NORWICH TO TILBURY

EN020027

Comments on Submissions received at Deadline 6

Suffolk County Council

Drawing Number: 10059280-ARC-EHR-ZZ-DR-ZZ-00432
Revision: C

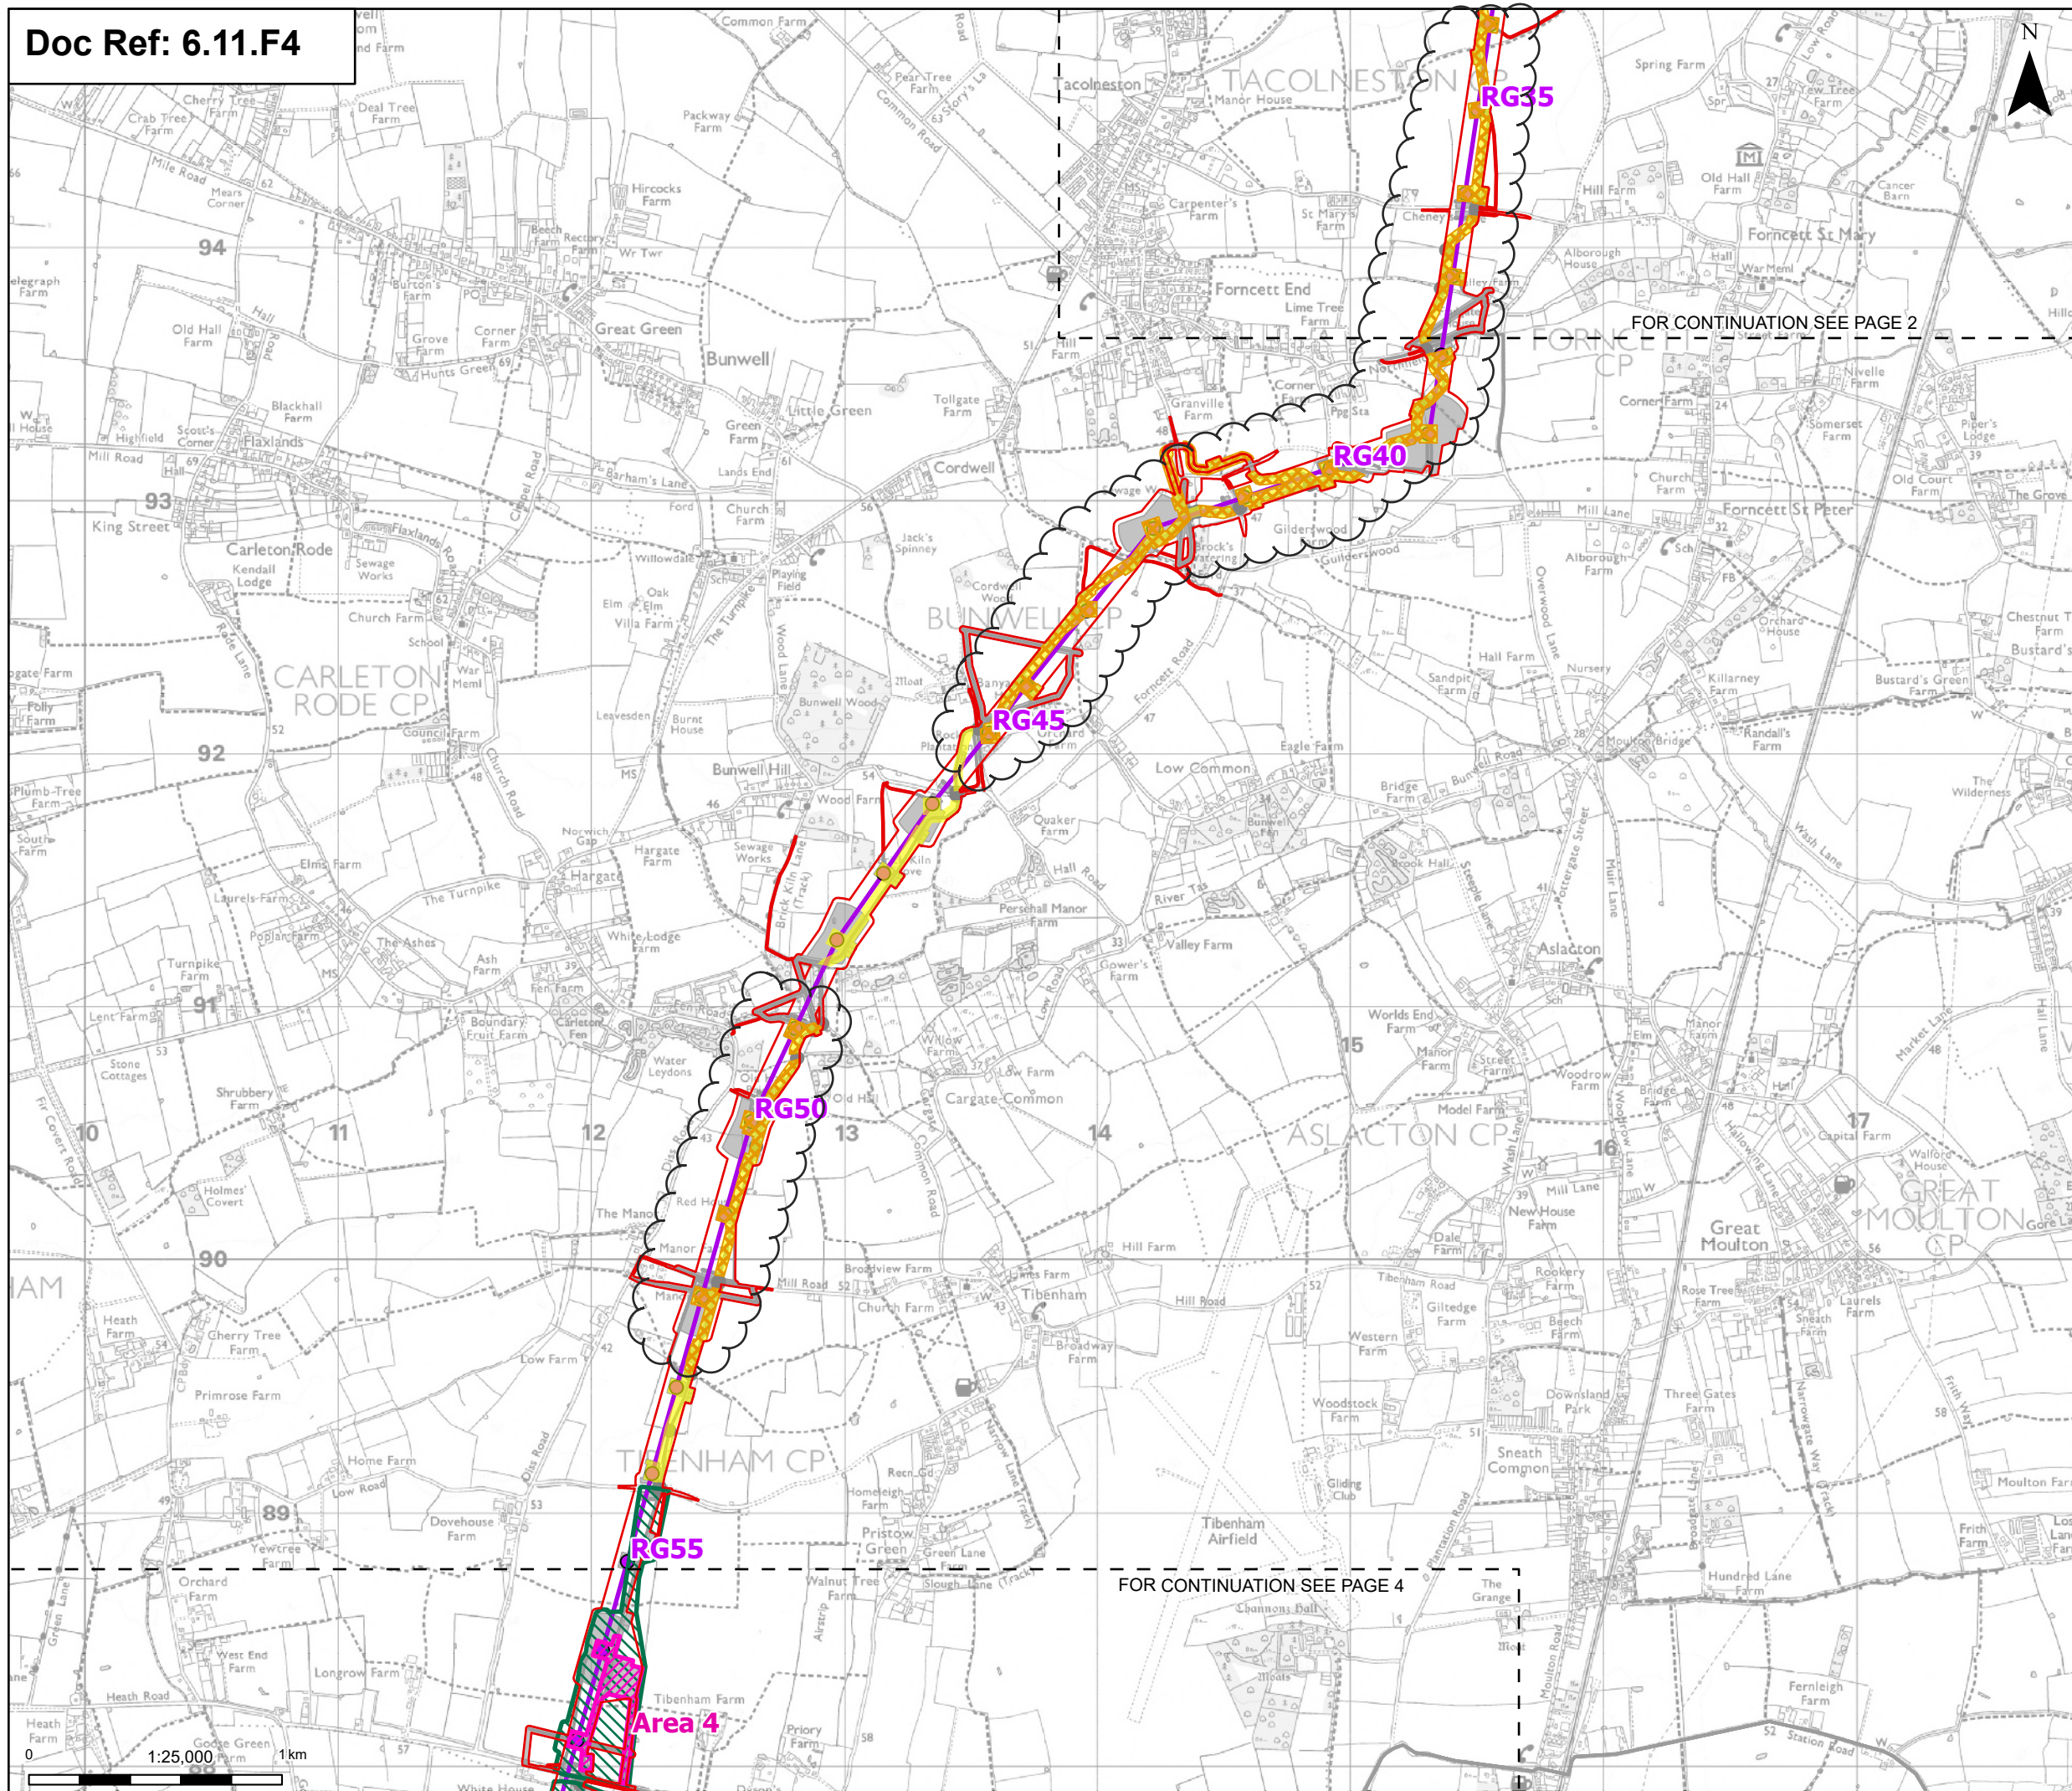
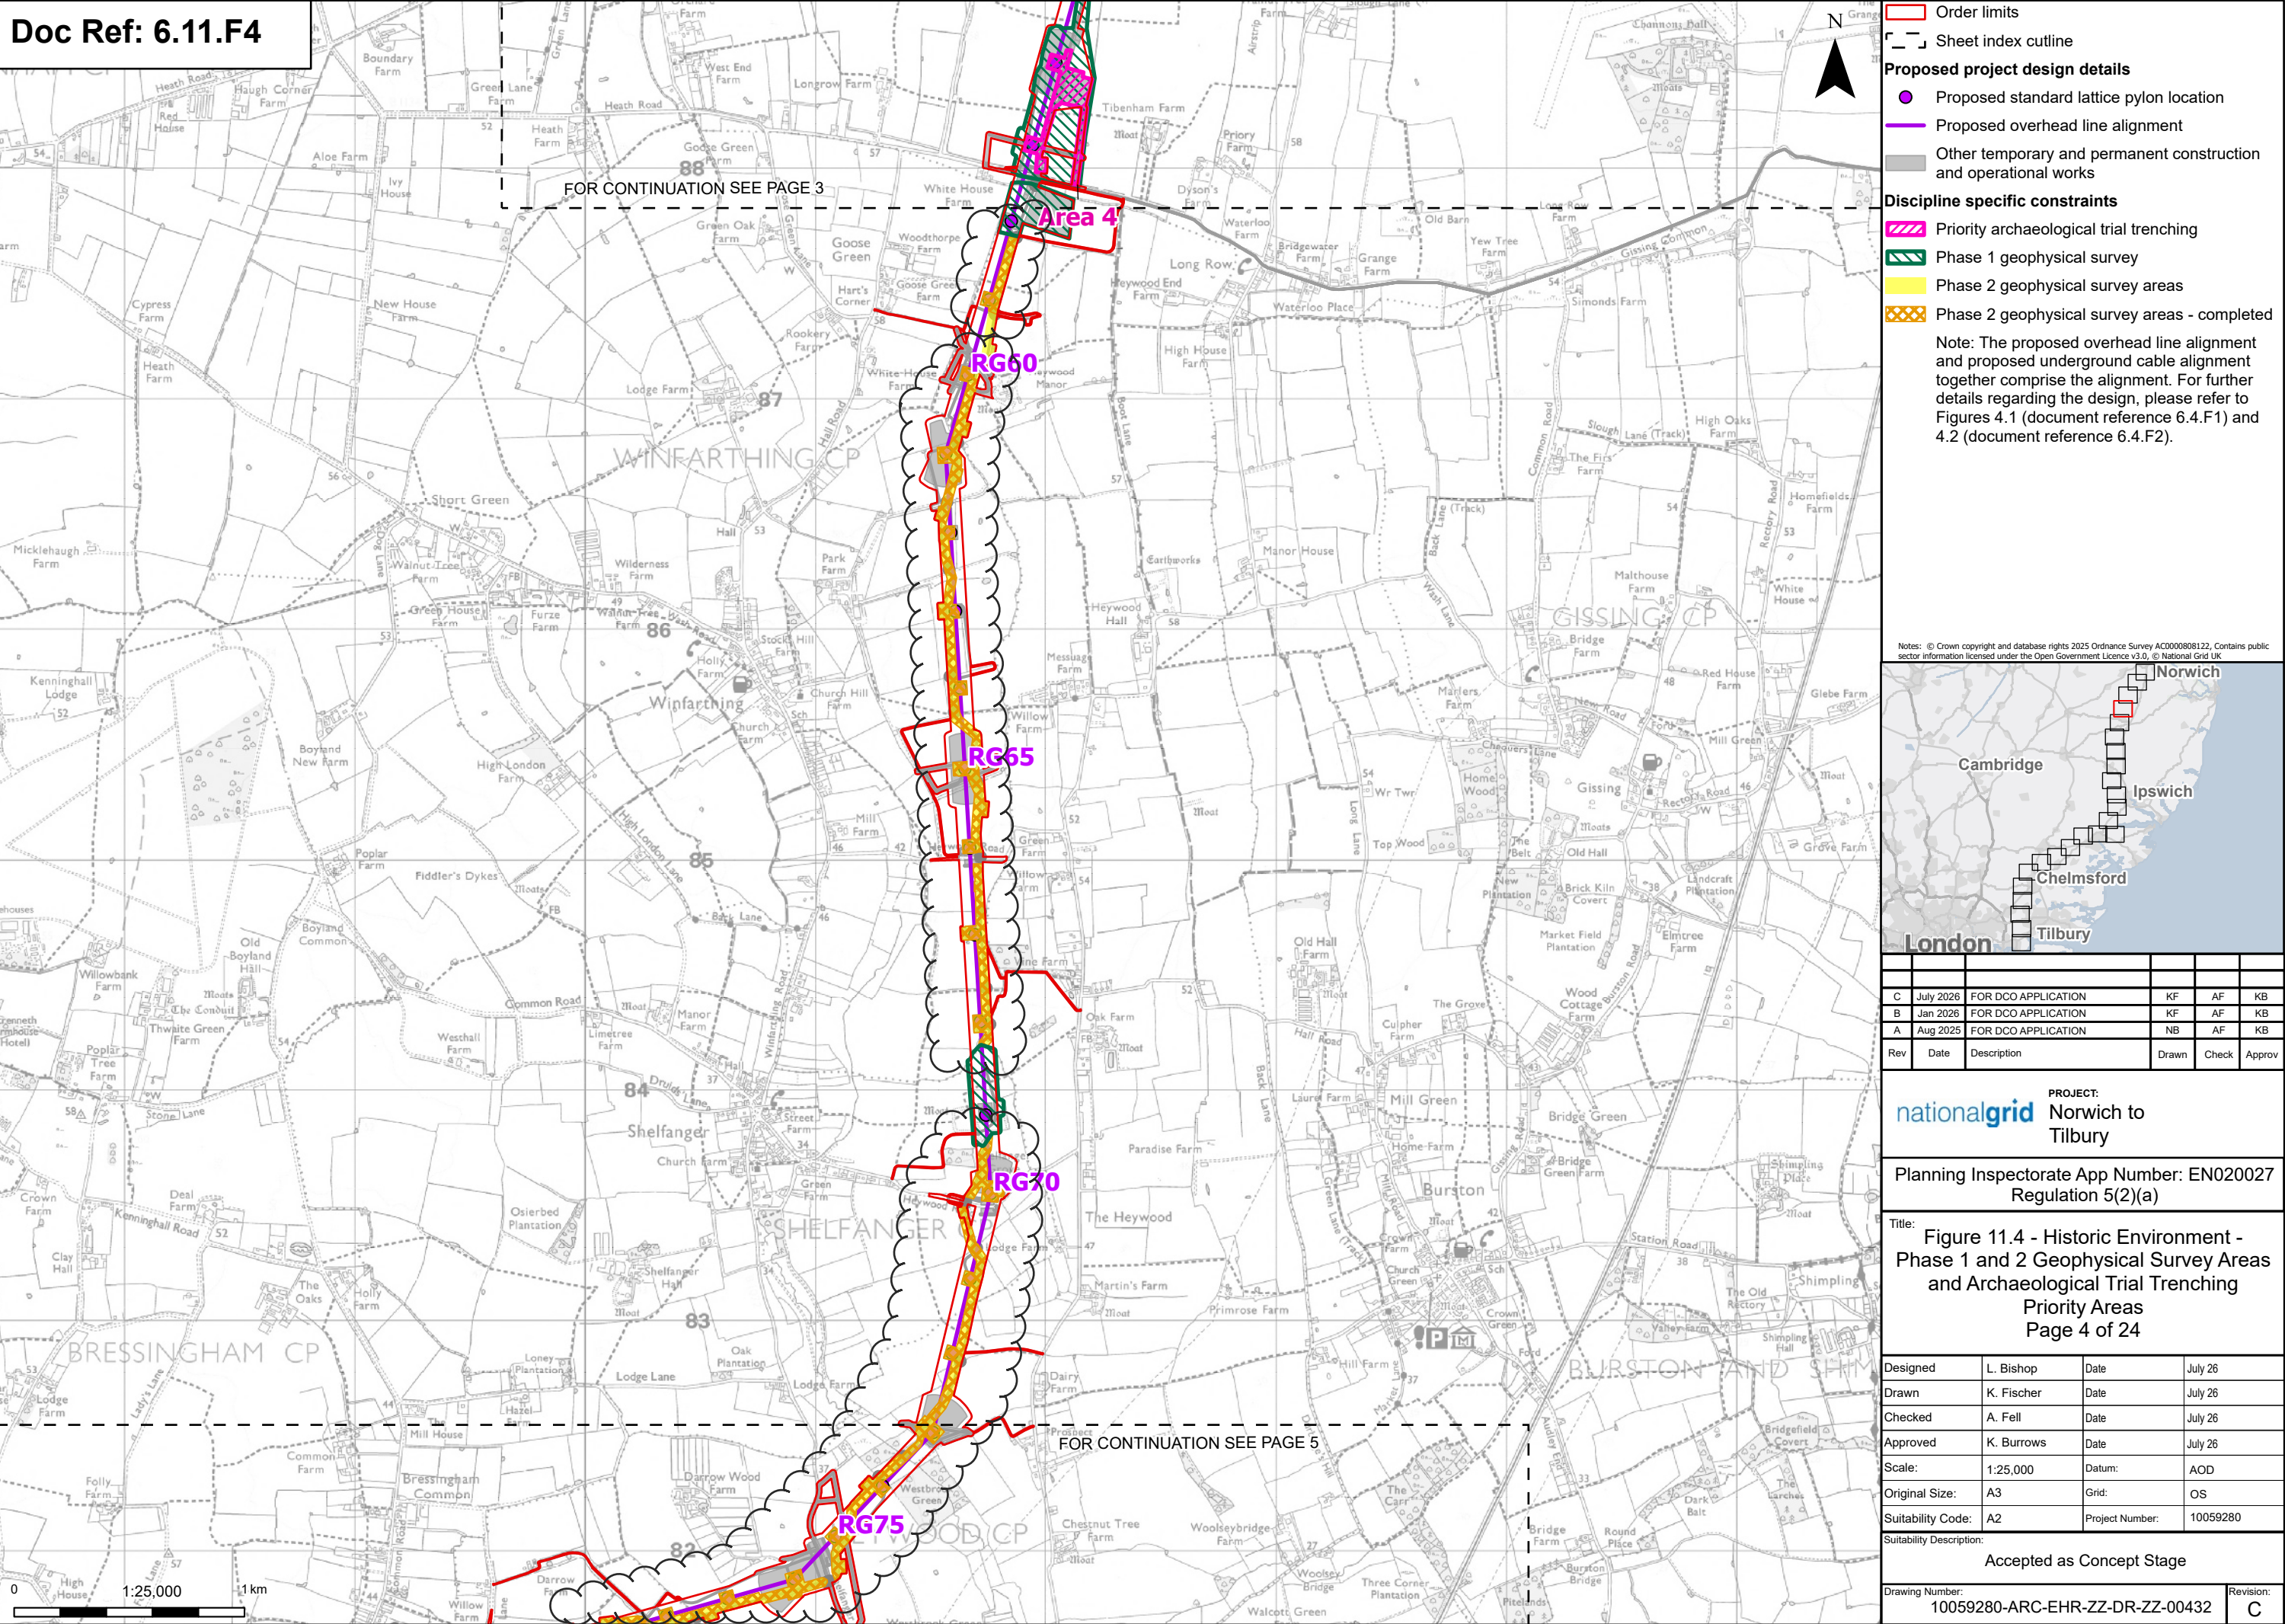
Table 4: 6.11.F4 (C) Phase 1 and 2 Geophysical Survey Areas and Archaeological Trial Trenching Priority Areas [REP6-069]			
Table Item	Service Area and/or Topic	Referenced Paragraph or Item	SCC's Comments

4.1	Archaeology	General Comment	This plan identifies the areas that have undergone priority evaluation, including priority geophysical survey and trial trenching. It also shows those areas where Phase 2 geophysical survey has been undertaken. SCCAS welcomes the submission of this plan as part of the Examination. Document 6.11.A8 Environmental Statement Appendix 11.8 – Phase 2 Geophysical Survey [REP6-065] states that approximately 86% of the Phase 2 area has been subject to geophysical survey. Figures in 6.11.F4 Phase 1 and 2 Geophysical Survey Areas and Archaeological Trial Trenching Priority Areas [REP6-069] indicate the unsurveyed areas, the applicant should state when these remaining areas will be surveyed or, where survey is not possible, how they will be archaeologically evaluated.
